URBAN DESIGN BRIEF

SITE PLAN CONTROL

SUBJECT SITE: 1981 CENTURY ROAD

REPORT DATE: FEBRUARY 20 2025

01 CONCEPT SITE PLAN
A1.0 SCALE: 1:400

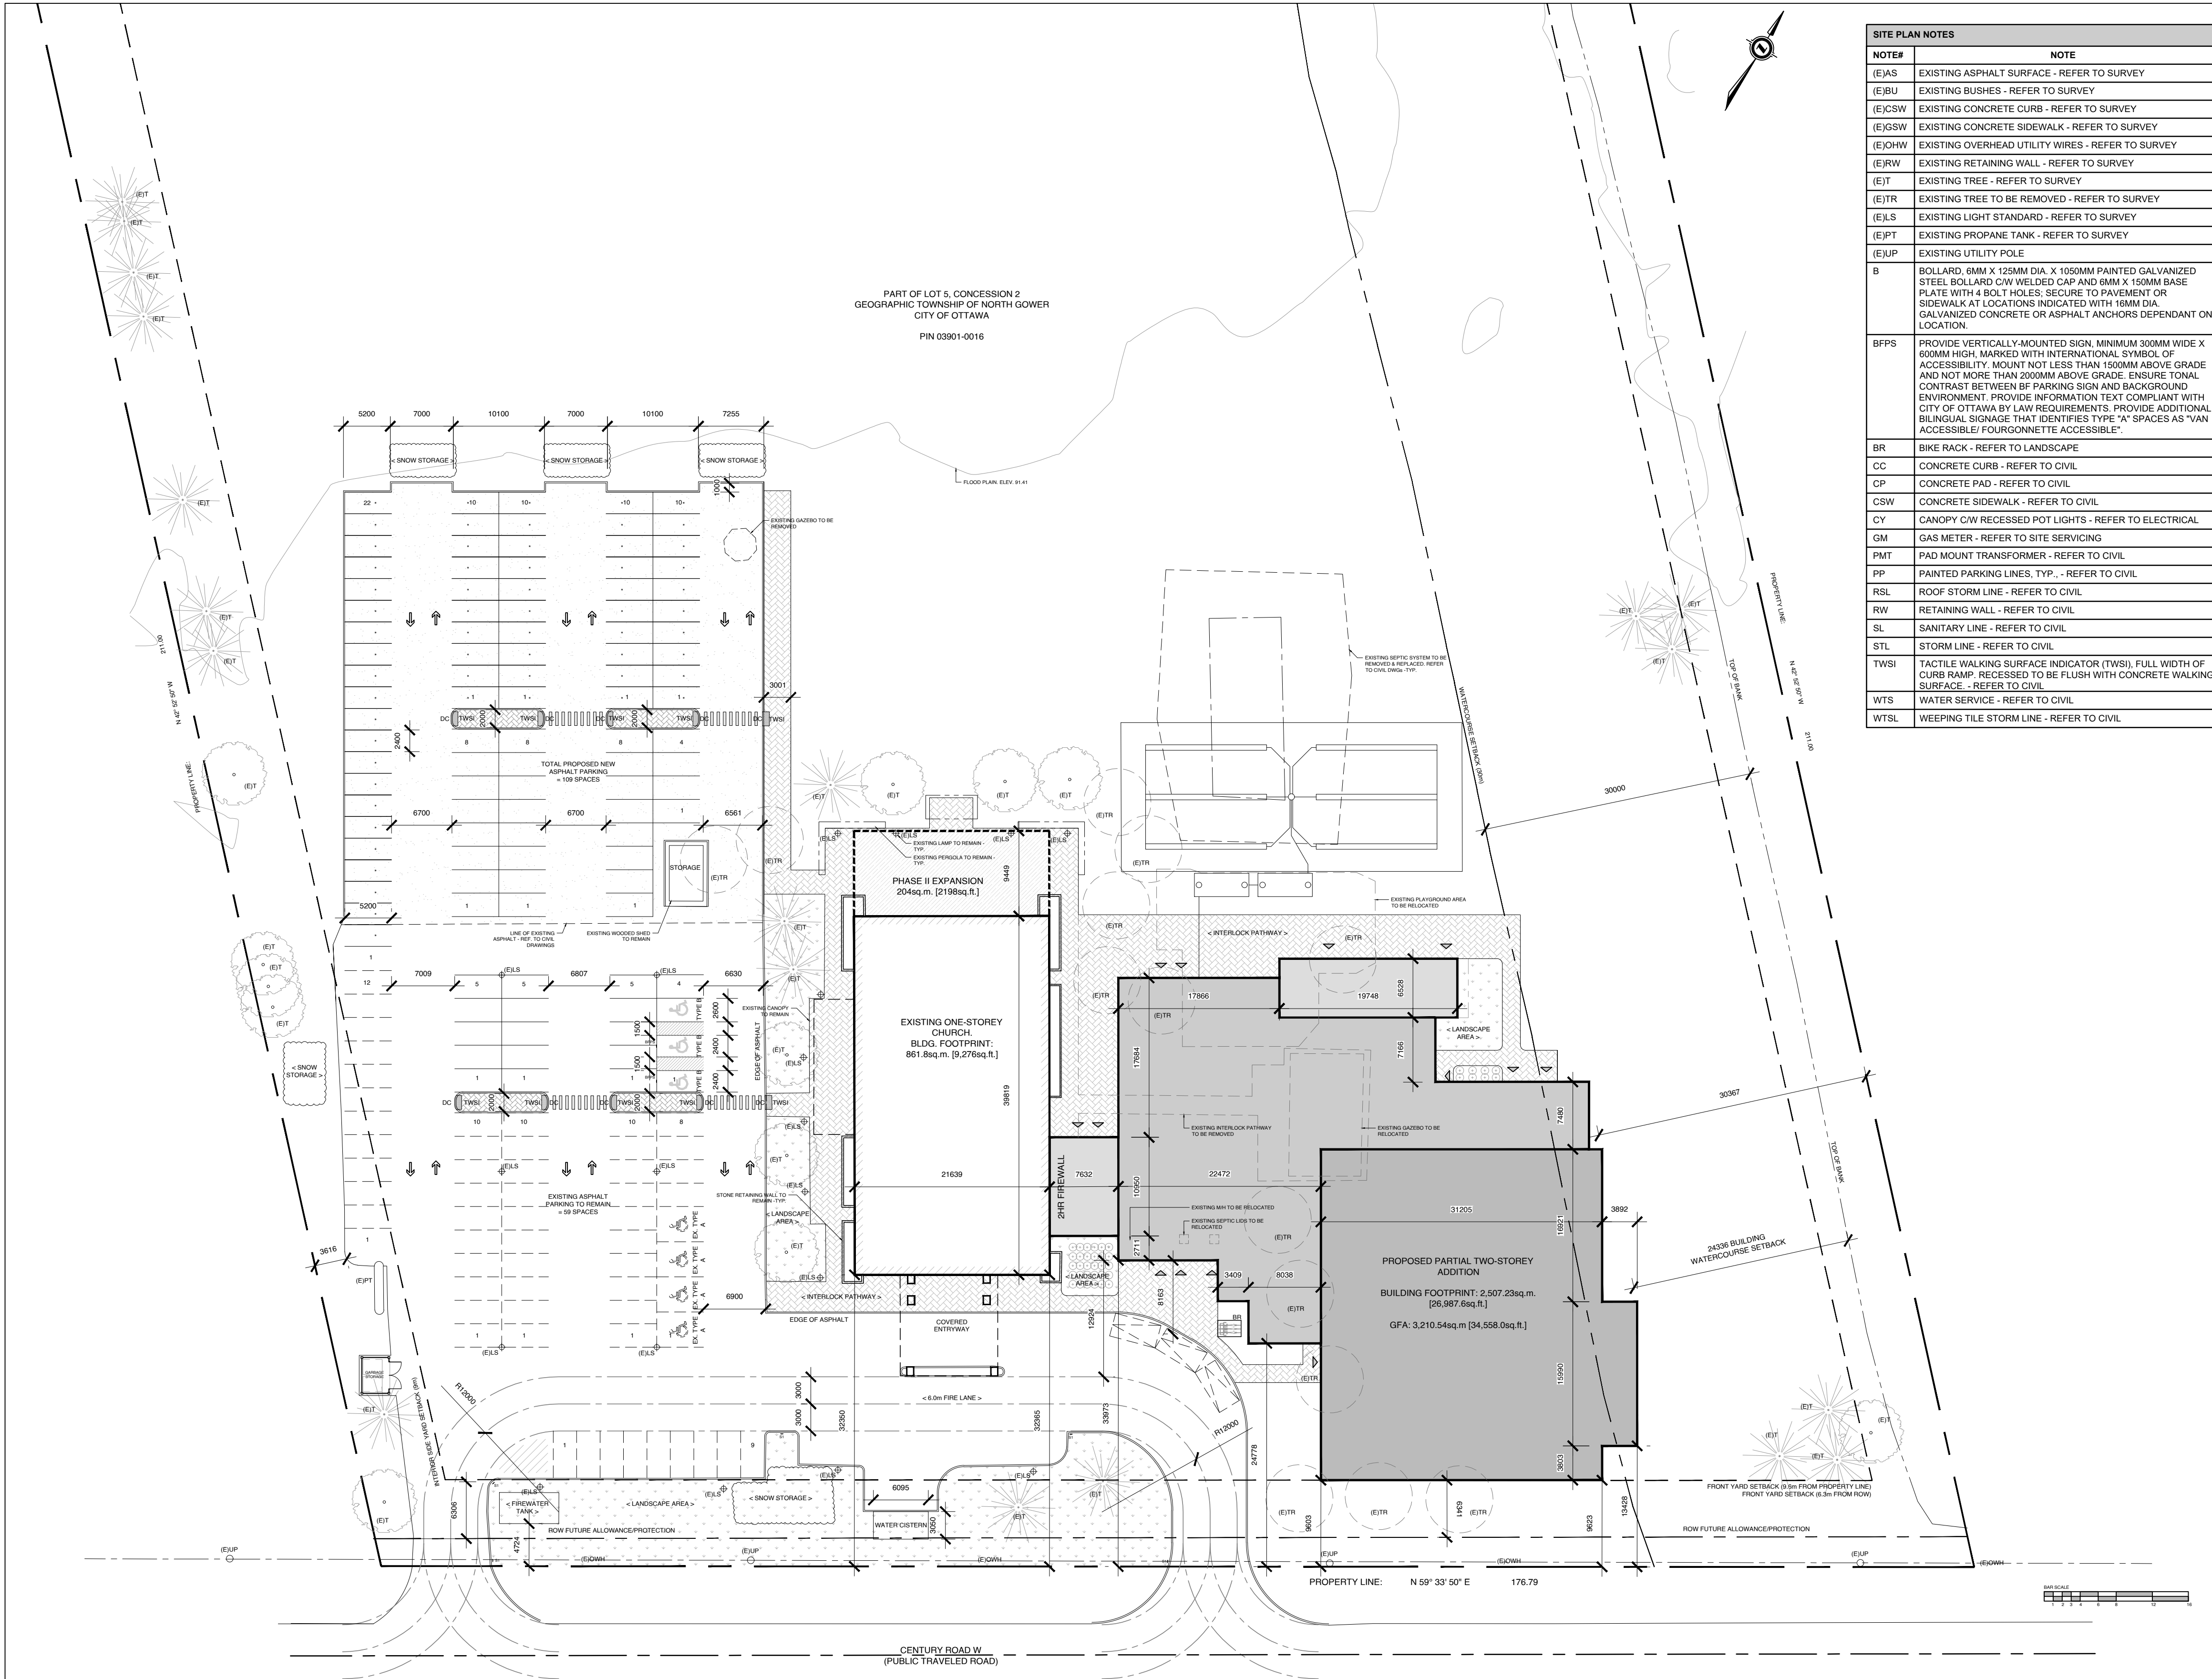
- **Q9:** Acknowledged.
- [We recommend consideration for safe pedestrian links from the large parking area to the building.
 - **Q9:** There is an interlock pathway in front of the building entrances that leads to a pedestrian link through the parking lot identified with depressed curbs, pavement paint, and TWSIs.

SHEET TITLE:
PROPOSED ELEVATIONS

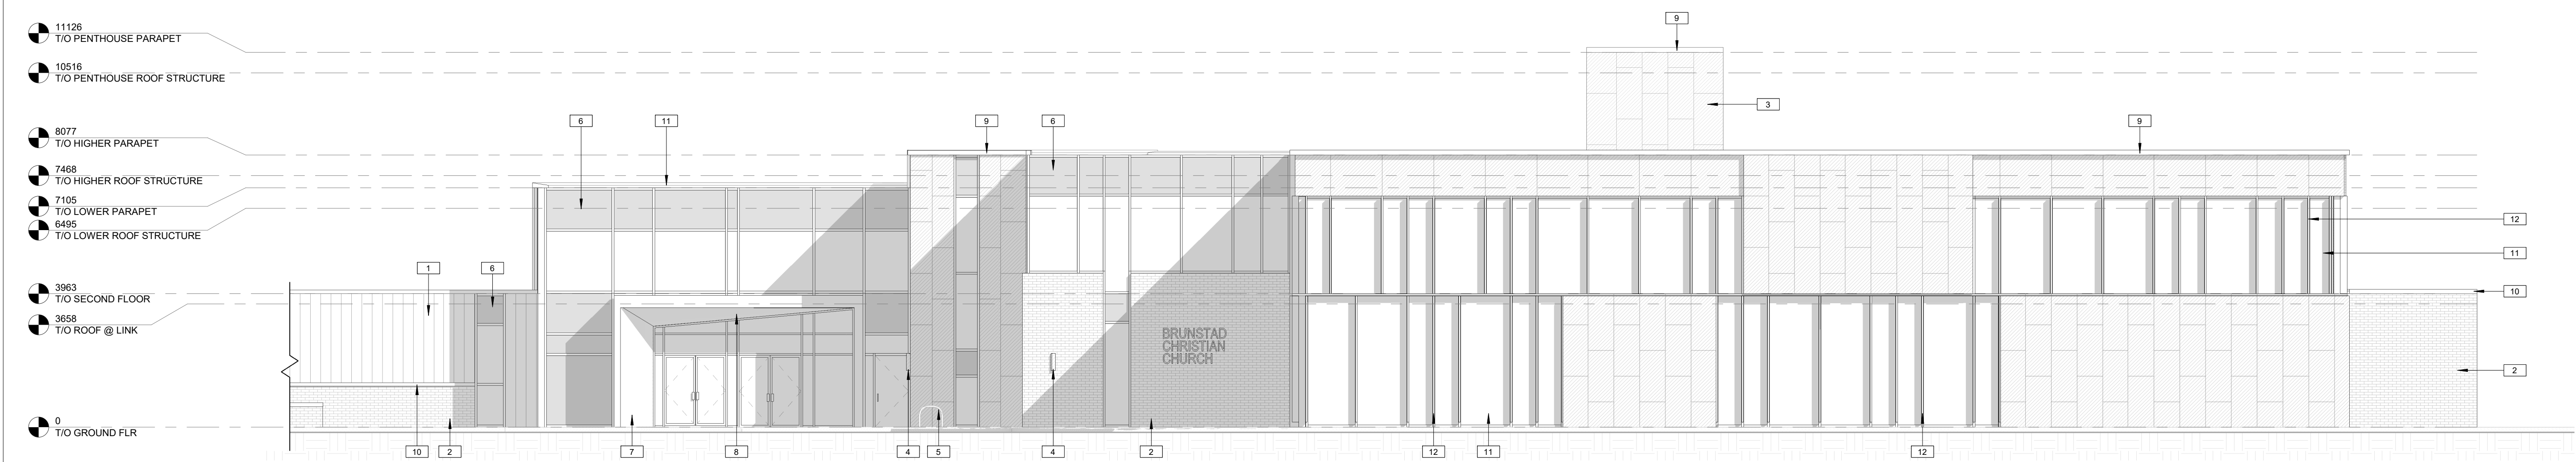
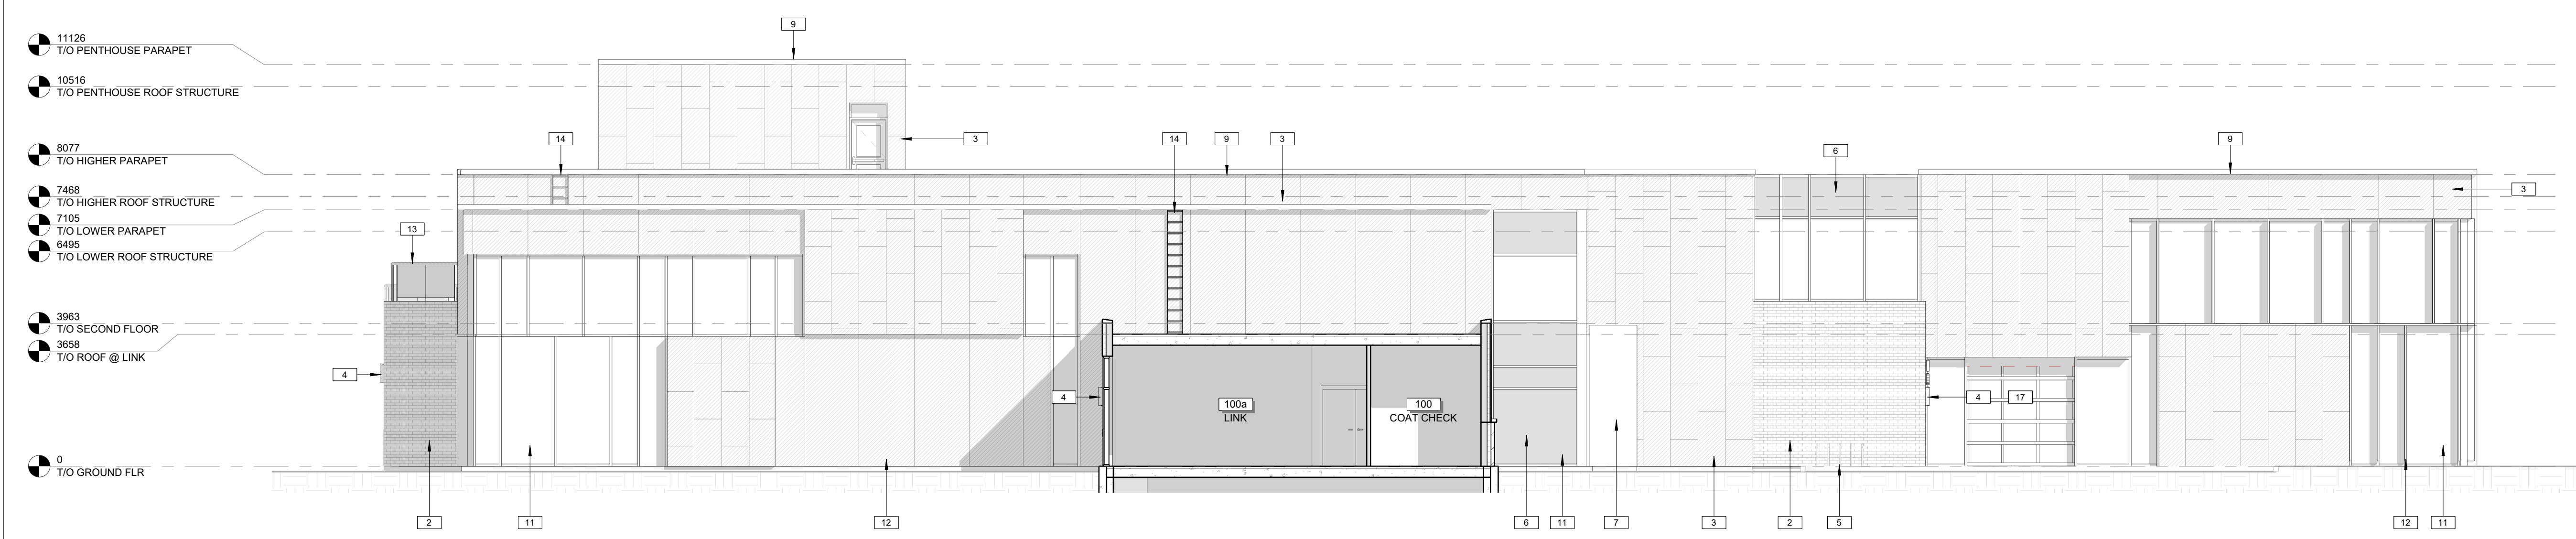
- [We notice the very long façade facing close to the street and recommend careful treatment of glazing and materials that support the use being a place of worship.

- **Q9:** Please see the provided elevations which indicate a high degree of glazing on the south façade.
- [We notice the lack of any religious iconography that would support the allowed use of 'Place of Worship' and recommend, if any are brought into the design, they be clearly visible from the public street.
